Summary of Changes

Figure 2.4: Proposed Development Layout

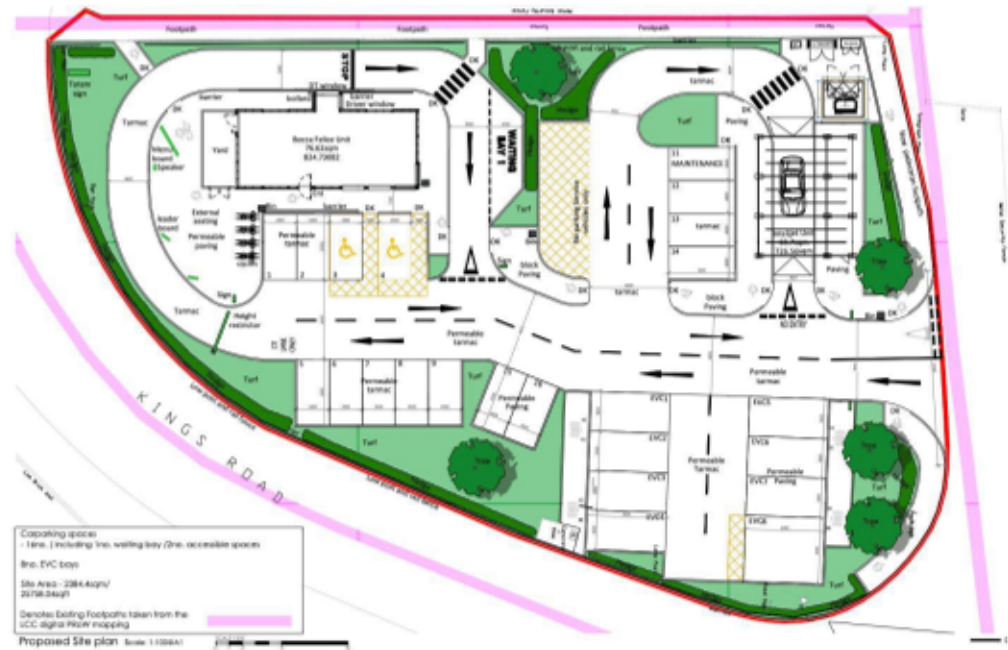
1. The Bocca Felice DT lane has been updated to avoid the ' Liability for maintenance' area (Shown in Brown)
2. The Standard Current Bocca Felice has a slightly deeper yard area . We have indicated the size of the original unit in Blue . The yard is approx. 500mm deeper than the original . The main Bocca Felice building size does not change ,

3. The waiting bay has been moved to the RHS to allow to for additional turning area . This puts it closer to the rear of the delivery area which results in a loss of hedgerow.

4. The Intelijet unit has been updated to the latest model which is larger than the previous one as previously discussed. The Blue outline shows the size of the unit for a comparison. The paved / landscaped areas around the unit have been tweaked to suit and you will notice the Substation has been moved . See below .

5. The substation has been relocated adjacent to the EVC spaces . Due the increase in size area of the intelijet is the original area is now a lot tighter. This is also the preferred location based upon the position of the EVC spaces.

6. Due to the reduction in space (Highways strip) the EVC spaces EVC1 to EVC 4 have now been rotated 90 degrees and are now accessible from the main access road.

7. We have noticed that the demise line was slightly incorrect . The original scheme showed the Footpath on the western boundary within the demise line when its actually on the outside as indicated .

8. The site area has been adjusted accordingly.
9. The pedestrian crossing has been reinstated as requested by SHDC.
